Martello Enterprise Centre Management Company Ltd.

8th January 2015

**Planning Application - LU/328/14/PL Unit 10 Martello Enterprise Centre,
Courtwick Lane, Littlehampton West Sussex BN17 7PA**

Proposed Extension for RJH Construction
Unit 10 Martello Business Centre, Courtwick Lane, Littlehampton
- AS EXISTING + Proposed Roof Plan

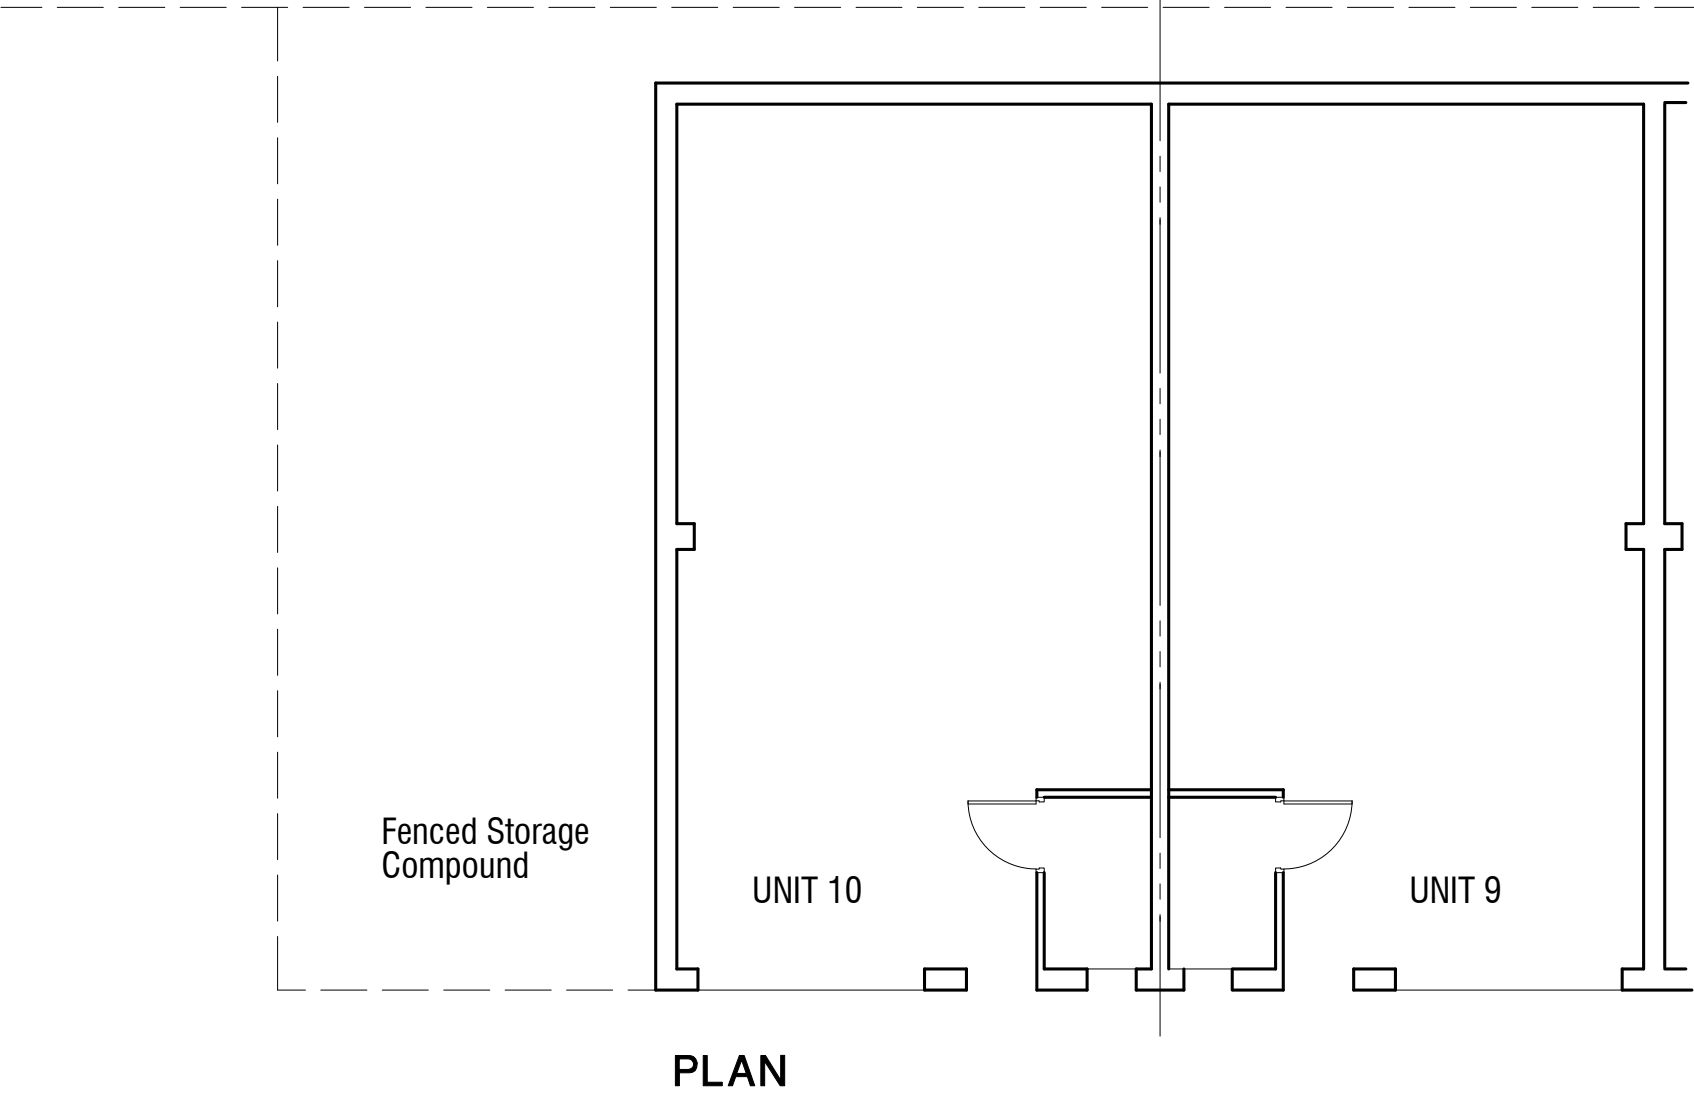
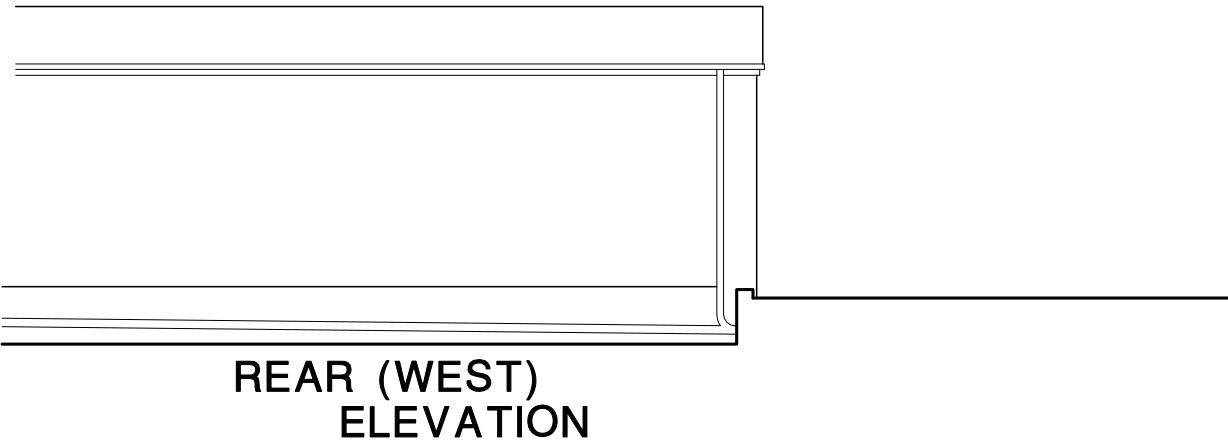
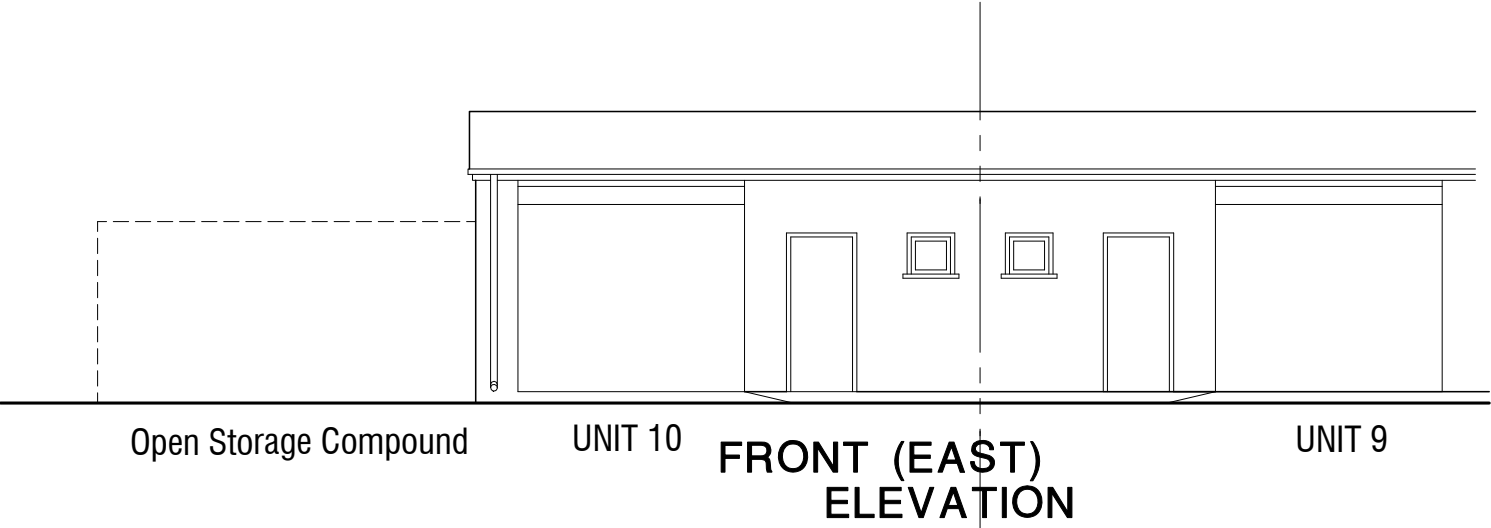
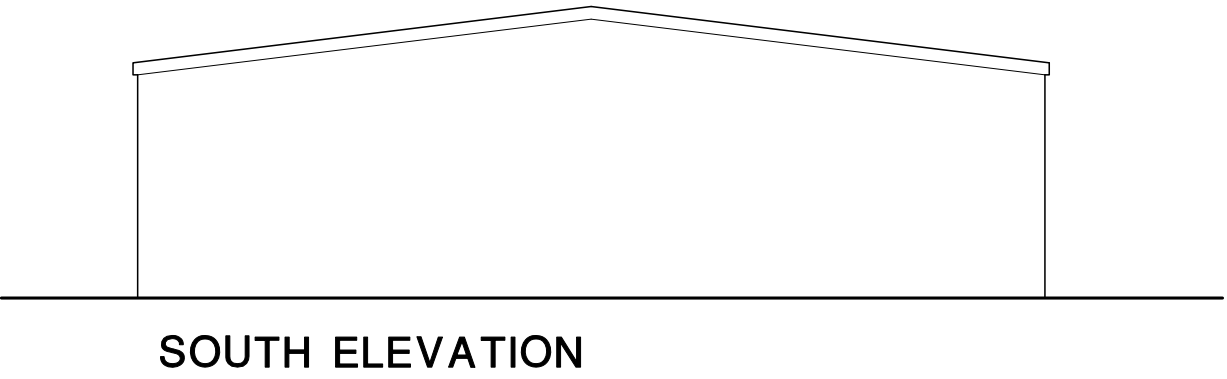
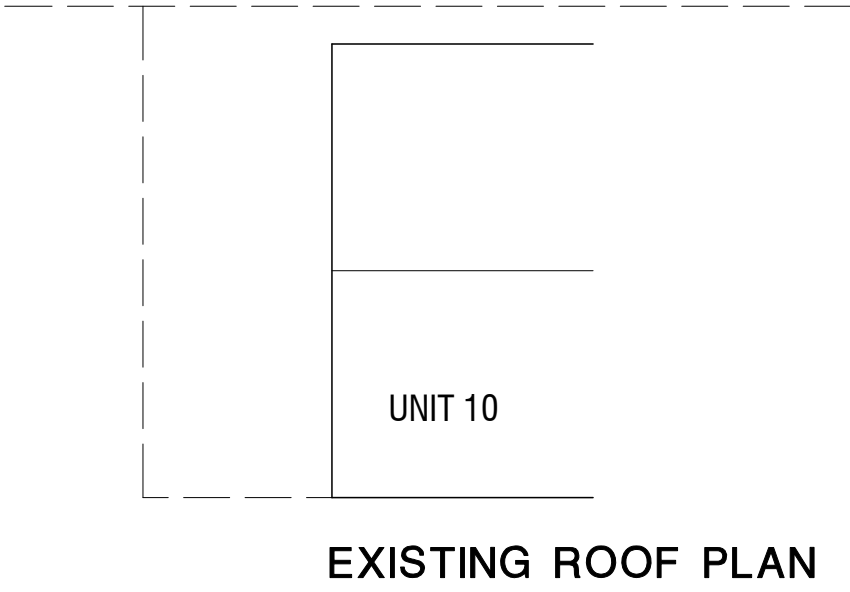
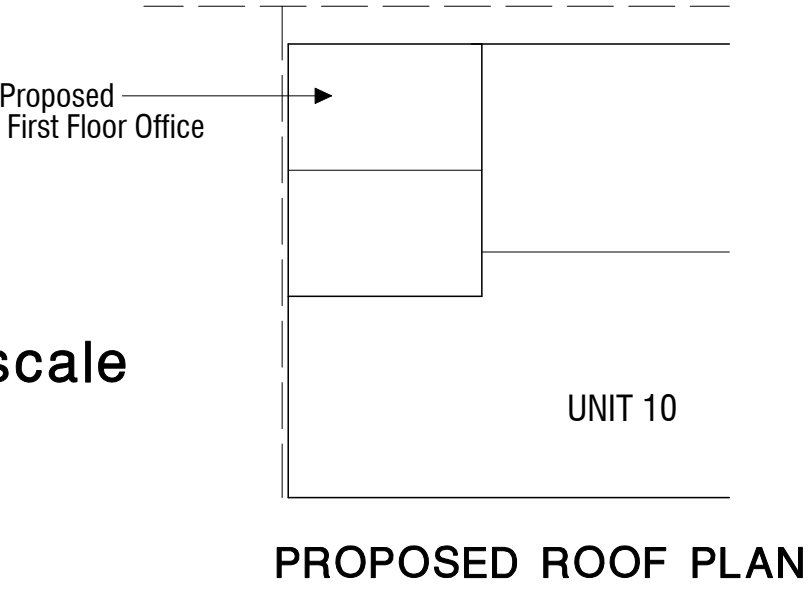
Parking Spaces: The placement of Parking Spaces is not under the control of the individual units. Your application shows a change of location of a parking space.

Your notation states an additional parking space.

Surface Water Drainage: Your application shows your new building using existing surface water drains within the common parts of the MECMCL.

Ramp: Your application shows an entry Ramp constructed on the MECMCL Common Parts.

Boundary: Your application shows a boundary outside of the building boundary which implies that you have control within that boundary.

Exit/Entry Door: Your application shows a new door opening onto the MECMCL Common Parts.

Storage Bins: Your application shows the placement of rubbish bins on the MECMCL Common Parts.
